CITY OF ALBUQUERQUE

**RE: Signal Pointe Subdivision
Pad Certification – All Pads
Engineer's Stamp Date 7-21-2016 (File: C20D0070)**

Based upon the information provided in your submittal received 9-20-2016 (electronic copy received 7-21-2016), the above referenced Grading and Drainage Plan is approved for Pad Certification of all Pads within the subdivision with the following condition:

TYPE	SIZE	PERCENT	PERCENT
70-100	9	9	9
50-70	4	4	4
35-50	2	2	2
2-10

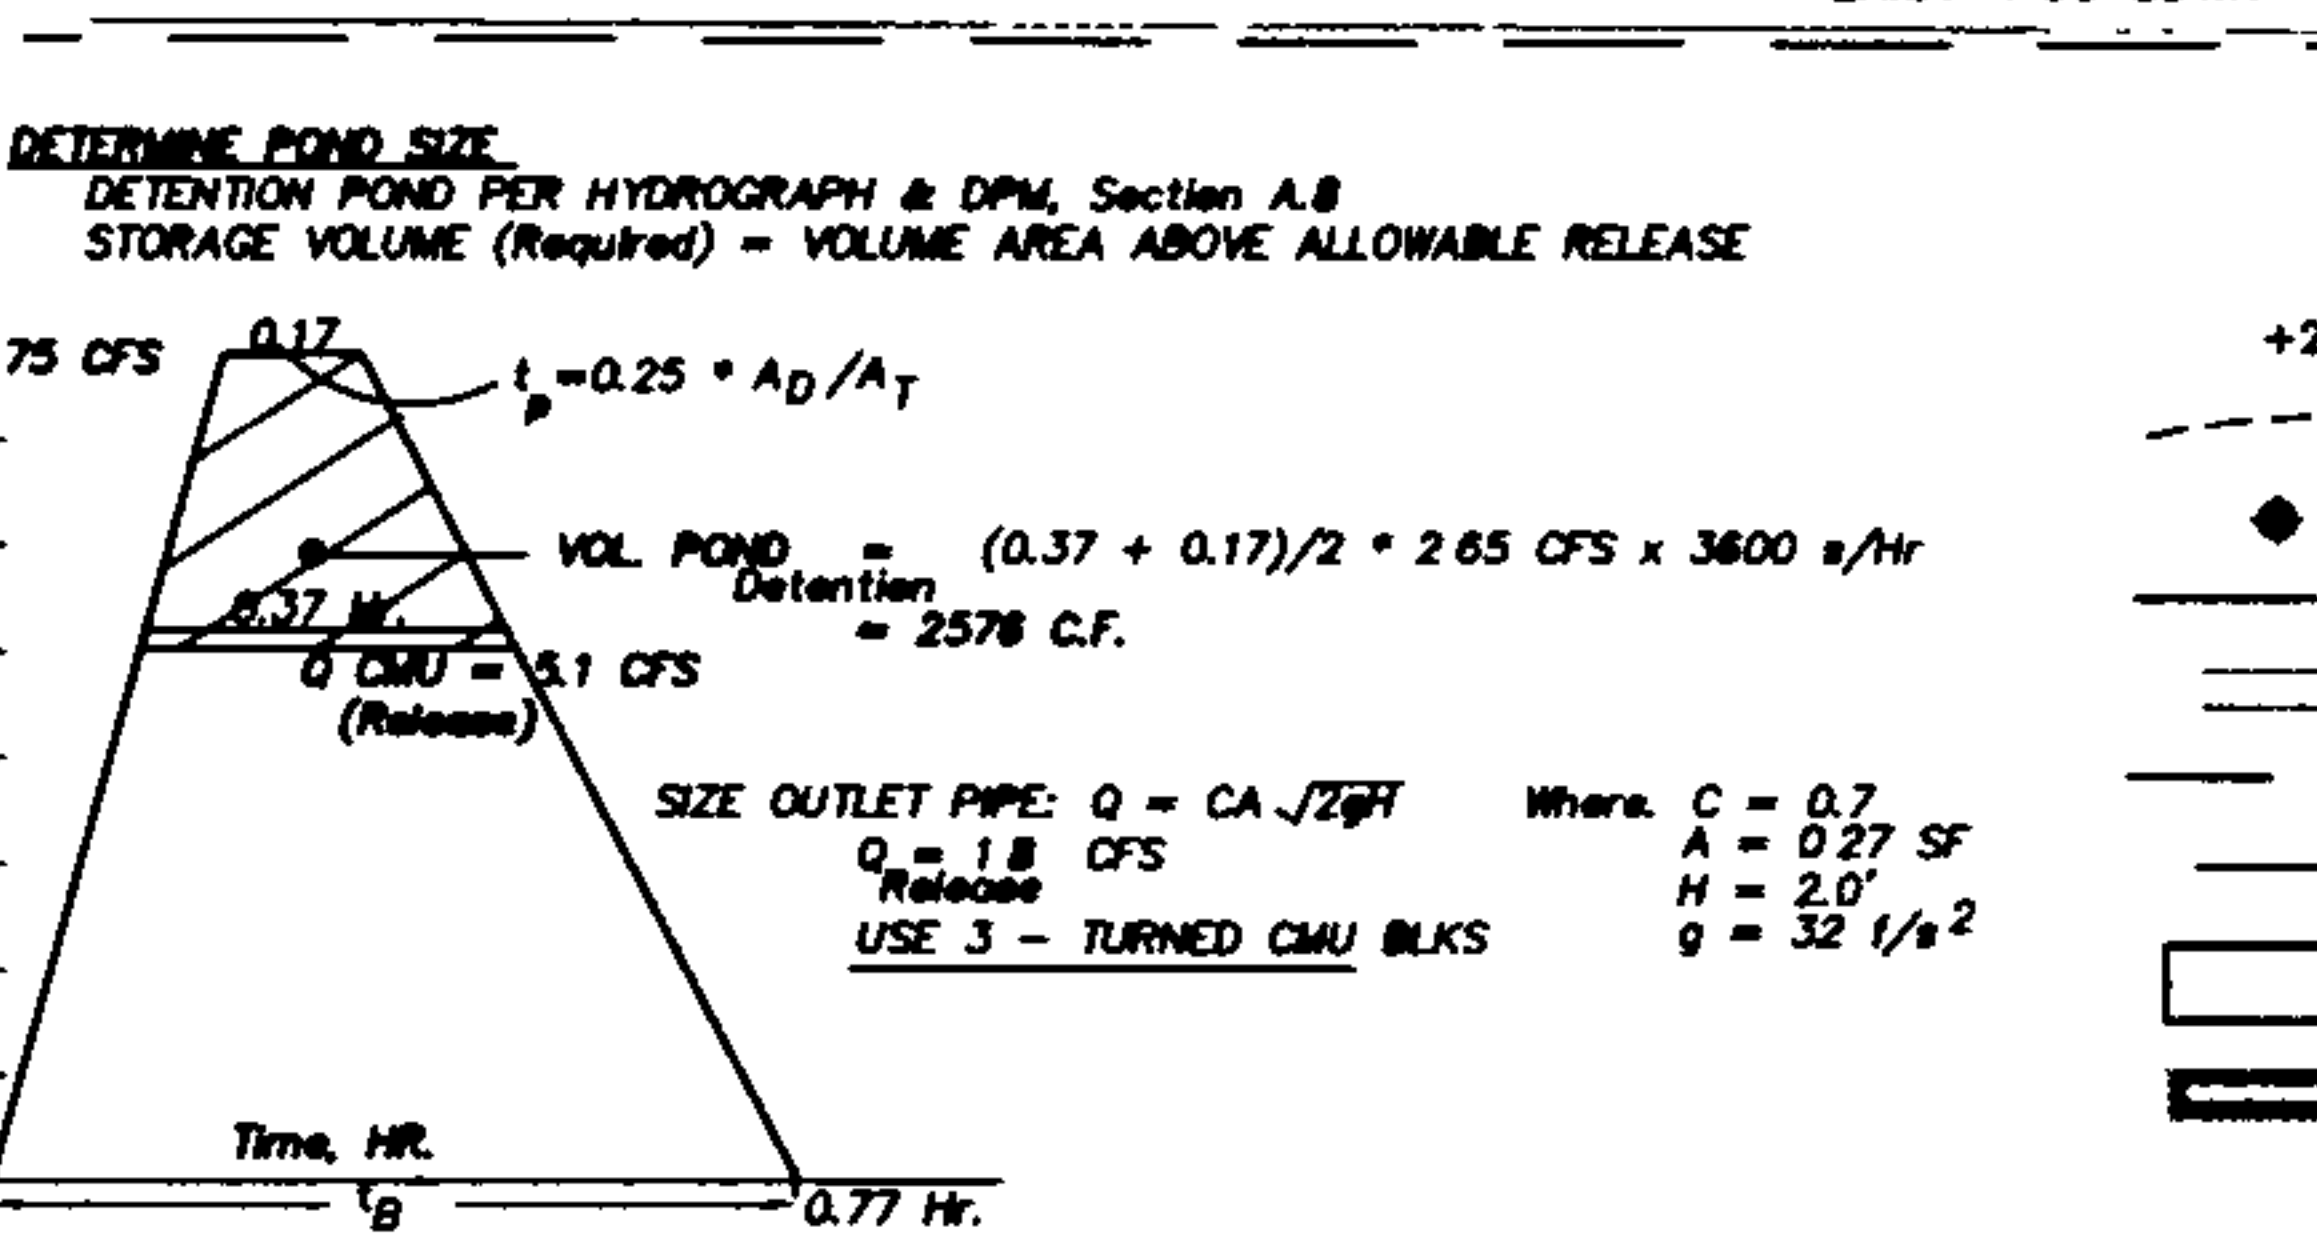
1. The turn blocks were not incorporated into the western wall, as an outlet for the water quality pond. This has the potential to adversely affect the home that is currently under construction on Lot 5 when the subdivision is built out. This will need to be addressed before any further action on this subdivision is approved (final plat, ROFG, future building permits).
